PARSONAGE FARM  
RIBCHESTER PR3 34E  
Application number: 3/2023/0569.

[REDACTED] Regarding the redevelopment of the barn and annex (3 dwellings) at parsonage farm Ribchester.

APPLICATION NUMBER : 3/2023/0569

SITE ADDRESS: PARSONAGE FARM  
OF PLANNING APPLICATION,  
CHURCH STREET  
RIBCHESTER  
PR3 3YE.

Location Plan

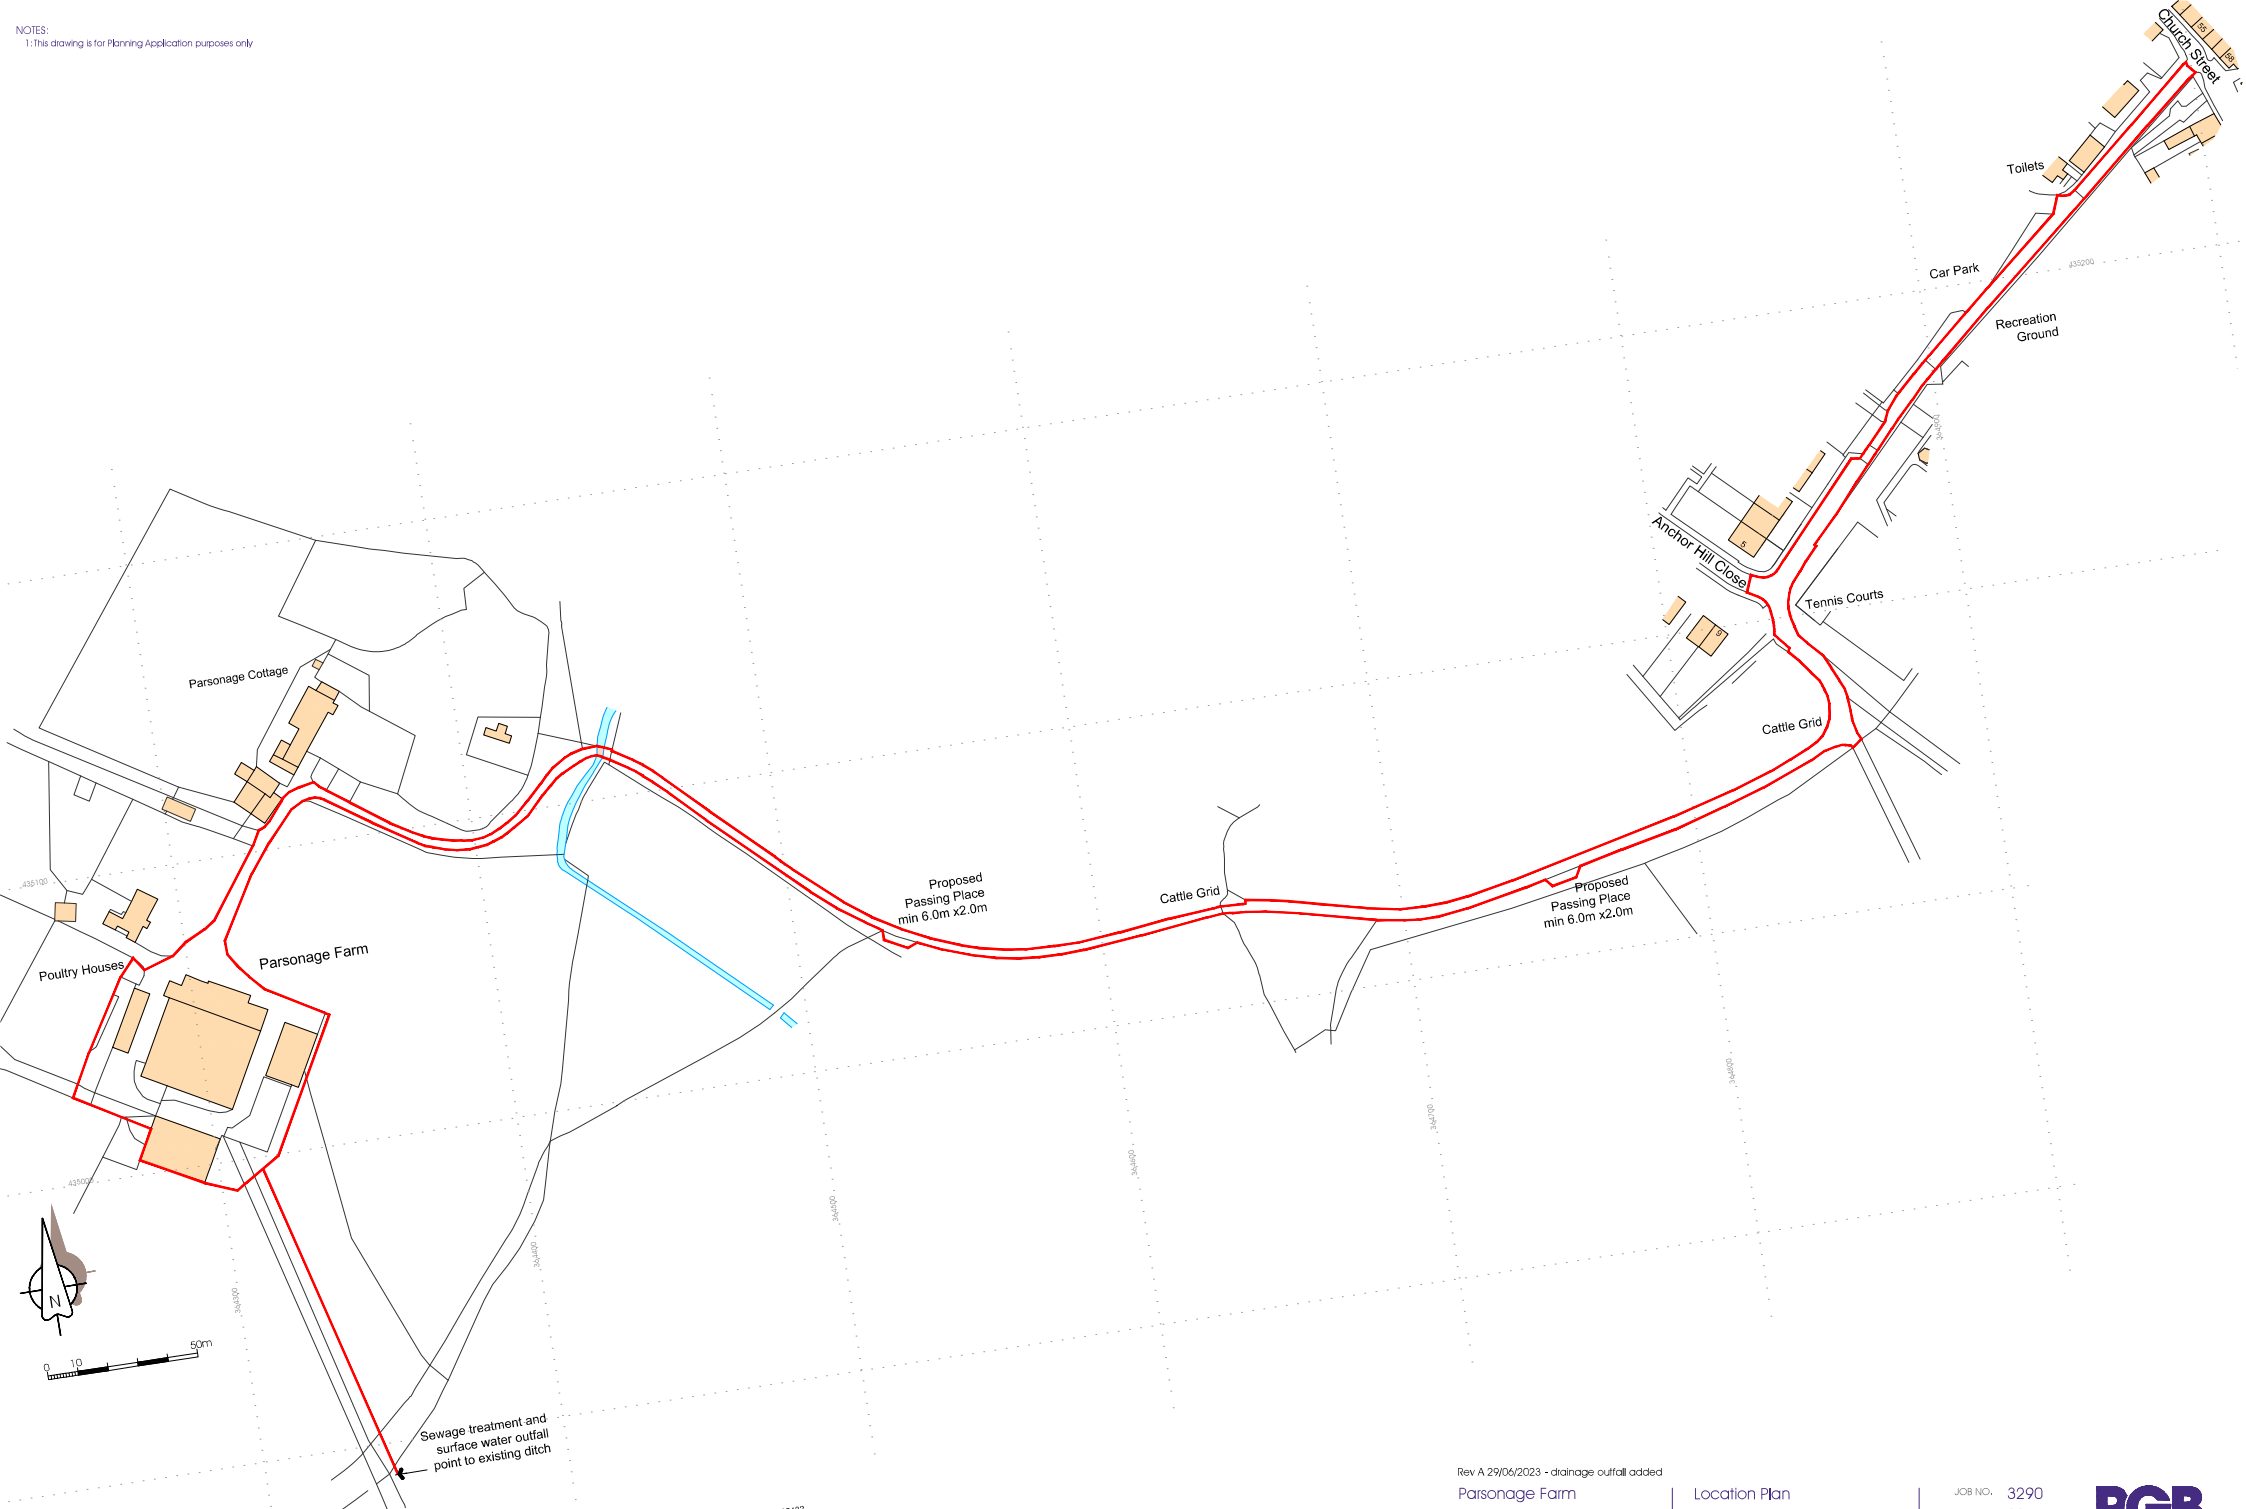
The plan shows that there will be no access to the back road "the agricultural track" which tells me the only route, access to all 3 new properties is by this one road, which is ill equipped to deal with the influx of 6-9 or more vehicles. The plans also indicate 2 passing places on this road, one proposed passing place is indicated on [REDACTED] which [REDACTED]

[REDACTED] I have highlighted this on the location plan drawing".

It has been assumed that a passing place of hard standing can be dug out [REDACTED] there has been no [REDACTED] This in my opinion shows [REDACTED] as if 3 new properties take preference over the [REDACTED] There will be no passing places [REDACTED]

Proposed Elevations and  
Roof Plan  
DATE 10.05.2023

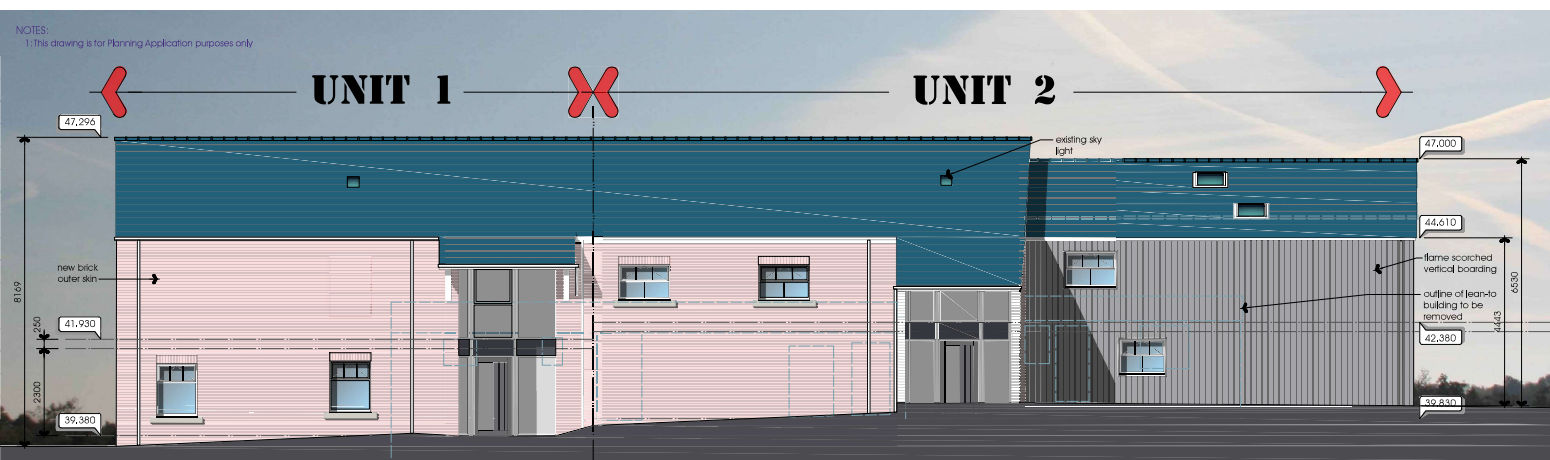
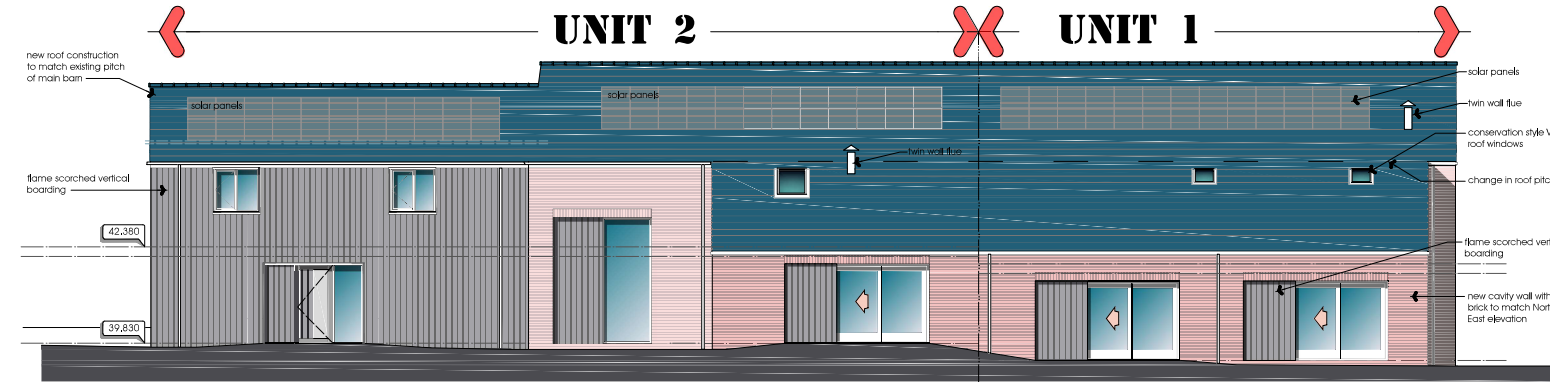
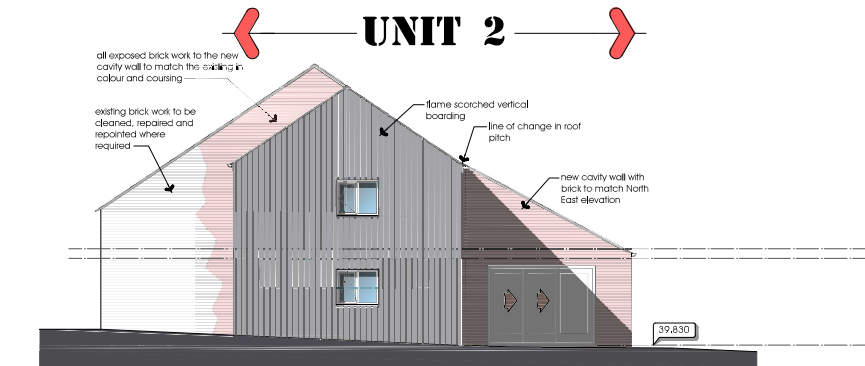
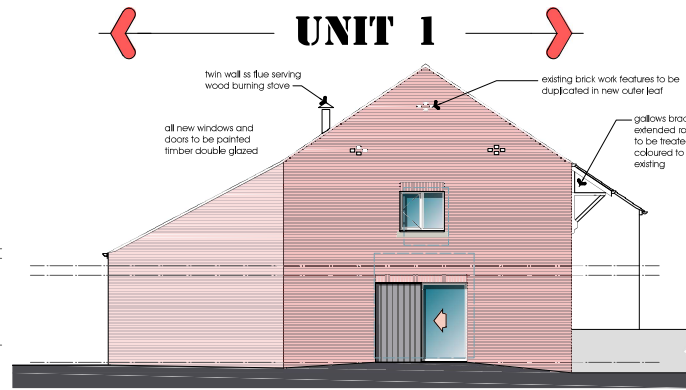
The external finish of the barn is (7.9 on the access statement) the proposal of a new brick skin. This is not in keeping with the surrounding buildings, I understand what is trying to be achieved but a brick finish would look totally out of character in the area. The "new brick skin" whether reclaim or new brick has nothing to do the historic value of the building and therefore would not blend in. I can understand the south facing gable that is already a brick finish staying the same.

I feel it is a great shame that a building like this in my opinion is being lost, as very little of the building will be visible apart from the king trusses, engulfed with the new brick skin. A 16<sup>th</sup> century barn like this is unique and for it to be lost as is a massive shame. I understand the northern side of the barn the extension will be finished in wooden cladding, this does not match anything on the farm at present, I understand this is a modern approach and fashionable thing.
